Your Ref: OWQC24417
Our Ref: EP/82/19/HH
Please ask for:
Mr Z Denton

26th September 2019

Erection of a fence
31 Cheviot Close East Preston

PROPOSED FRONT ELEVATION Scale 1:100

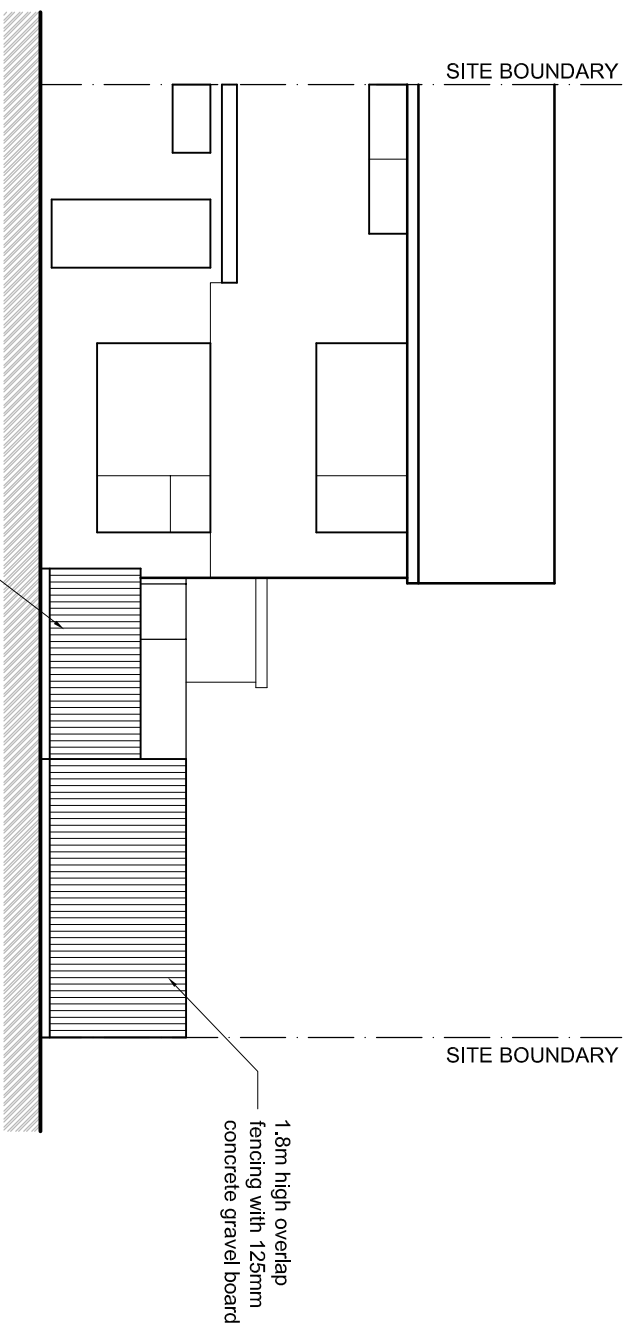
The property is on a prominent corner site between Cheviot Close and Cotswold Way. The committee felt the proposed expanse of overlap fencing was too high to be unbroken by either some degree of soft landscaping or possibly a lower height of overlap fencing topped with a trellis through which some soft landscaping could be trained. If either of these suggestions were to be considered, the committee would happily reconsider its objections.
